**Stantec Architecture Inc.**  
722 12th Street NW Suite 100, Washington DC 20005-3957

**Reference:** New Mexico Proton Advanced Cancer Therapy (NMPACT)  
Response to Development Review Board Comments  
Project: PR-2022-007588  
Application: SI-2022-01658

NEW MEXICO CANCER CENTER
4901 LANG AVE. NE
ALBUQUERQUE, NM 87109
Title
BUILDING ELEVATIONS

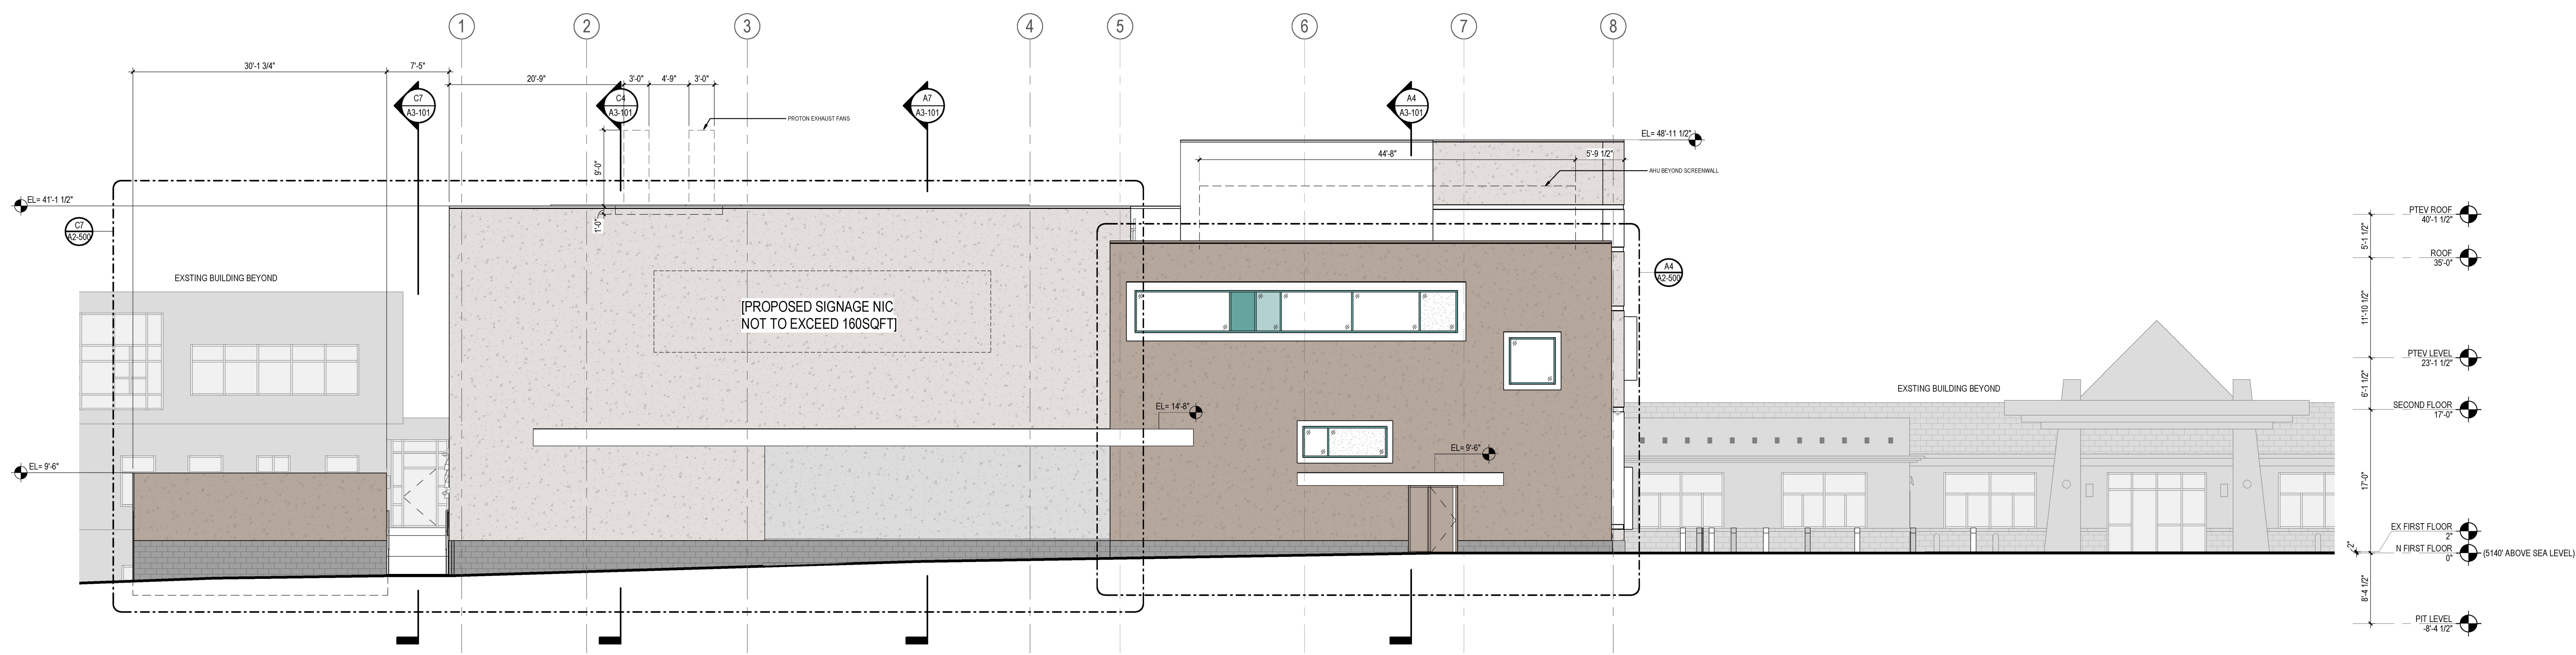
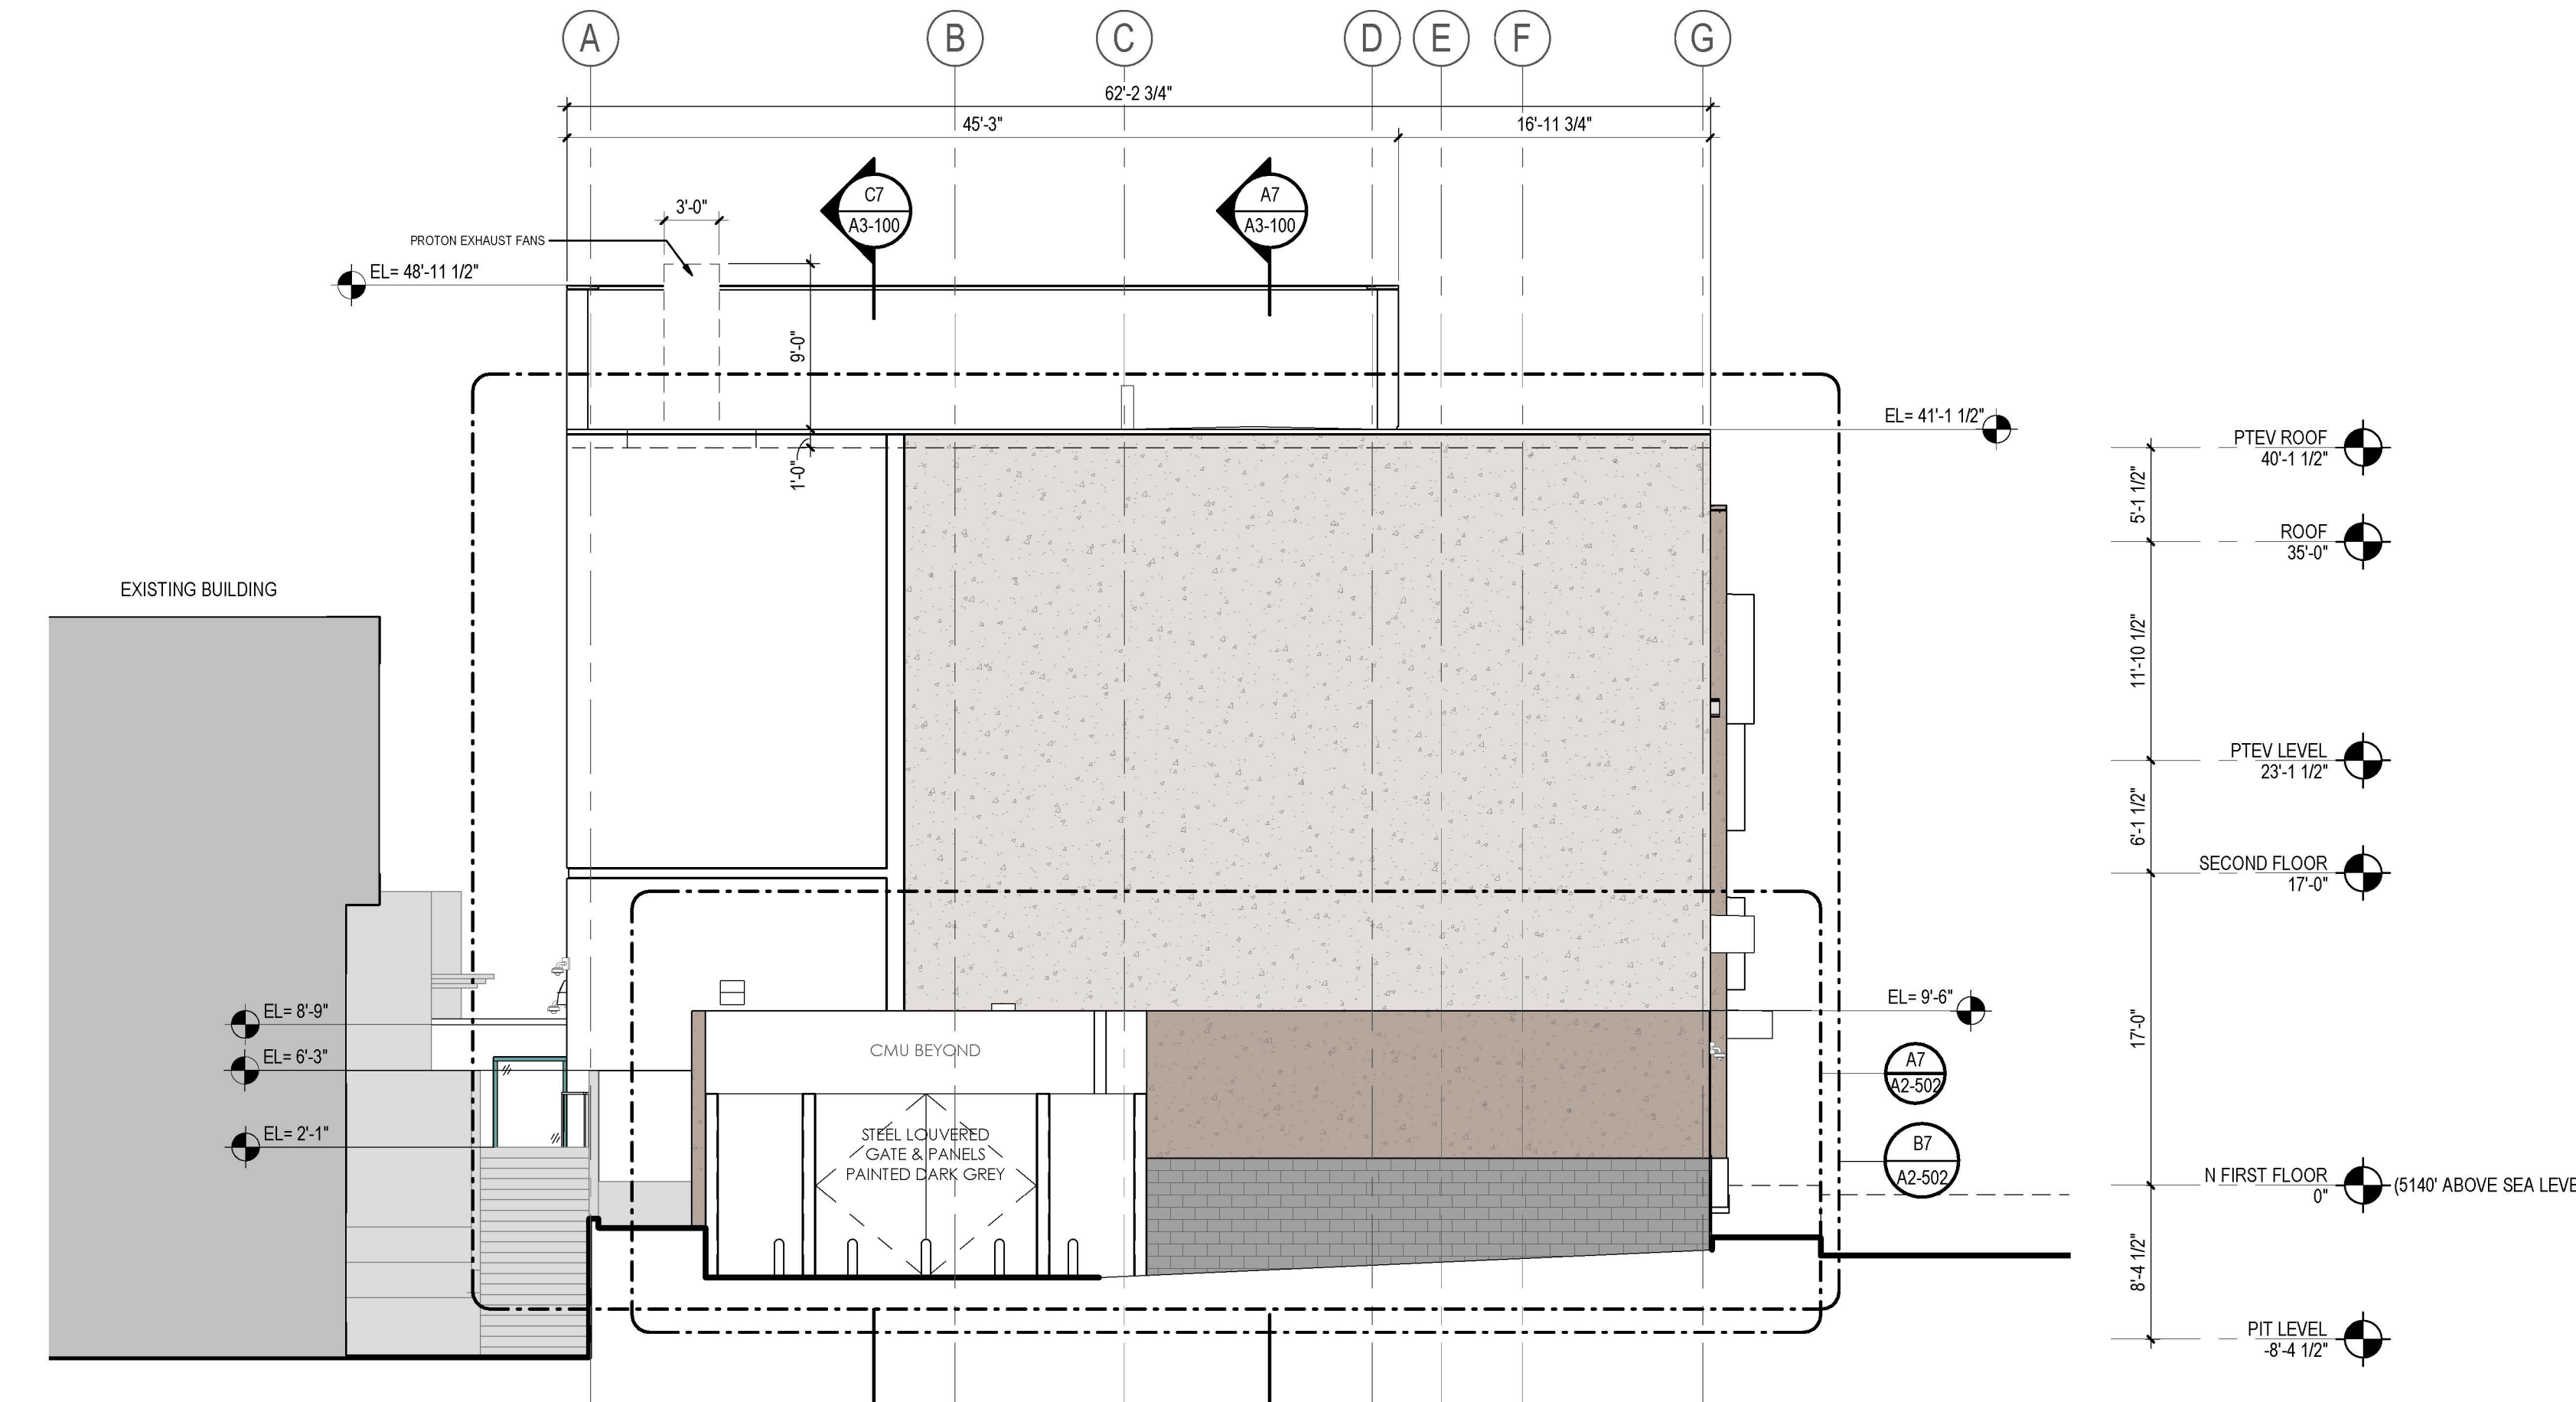
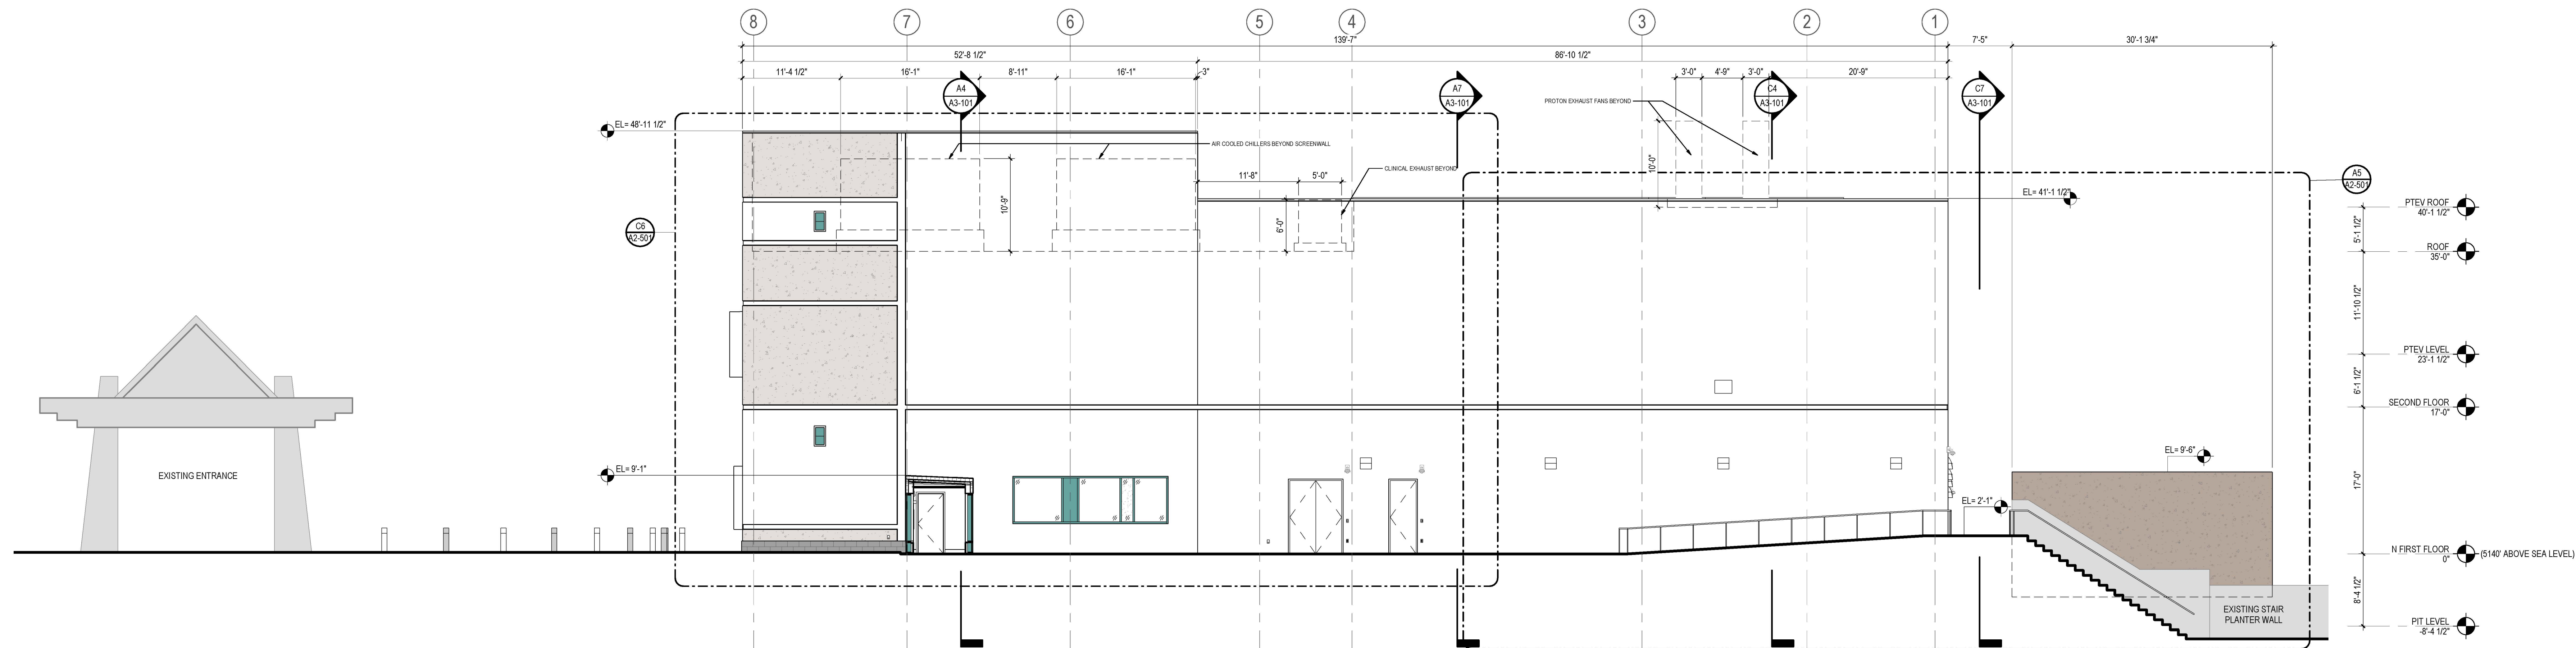
2. The site is located within the Journal Center Master Plan. A letter of approval was received from the Journal Center Architectural Review Committee approving the proposed development. Staff needs more information on the façade to determine compliance.

- a. *Stantec Response: Please confirm that the compliance issue is the same one identified below in Planning comment 3.*
3. The applicant must provide proof how the building/façade design requirements are being met per 5-11(E) of the IDO as notes on the amended Site Plan and/or in a comment response letter.

- a. *Stantec Response: The project complies with relevant sections of 14-16-5-11(E). Under 5-11 ( E )(2) Façade Design:*
    - i. *5-11 ( E )(2)(a)(1). The south and east facades provide a sense of human scale at the ground floor with unique base material, sunshades, offset in wall plane, and large bank of glazing. See attached project rendering.*

- ii. *5-11 ( E )(2)(a)(2). The street-facing façade (south elevation) incorporates two features. Specifically:*
      1. *Item (b). Windows on upper floor. There are two windows on the second floor and their combined length exceeds 30% of the façade length. The windows combine for 44 feet and the façade is 140 feet.  $44/140 = 31\%$  of the façade. See attached project rendering and Building Elevations, Sheet A2-100.*

2. *Item (d). Elements that provide shade or protection from weather. There are two sunshades, and their combined length exceeds 30% of the façade length. The element also occurs more frequently than every 40 feet. The sunshades combine for 100 feet and the façade is 140 feet.  $100/140 = 71\%$  of the façade. See attached project rendering and Building Elevations, Sheet A2-100.*

- iii. *5-11 ( E )(2)(a)(3). The street-facing façade (south elevation)- longer than 100 feet - incorporates more than one required feature. Specifically:*

1. *Item (c). Offset or projecting element. There is a niche that is 3'6" offset from main façade plane that is 30% of the façade length. Additionally, there are two sunshades that project more than 6" from the façade and cover 71% of the façade. See attached project rendering.*

2. *Item (f). Art. There is an 11-foot high by 42-foot-wide section of the façade (at ground floor) that is designated for an Owner-furnished tile mural. See attached project rendering.*
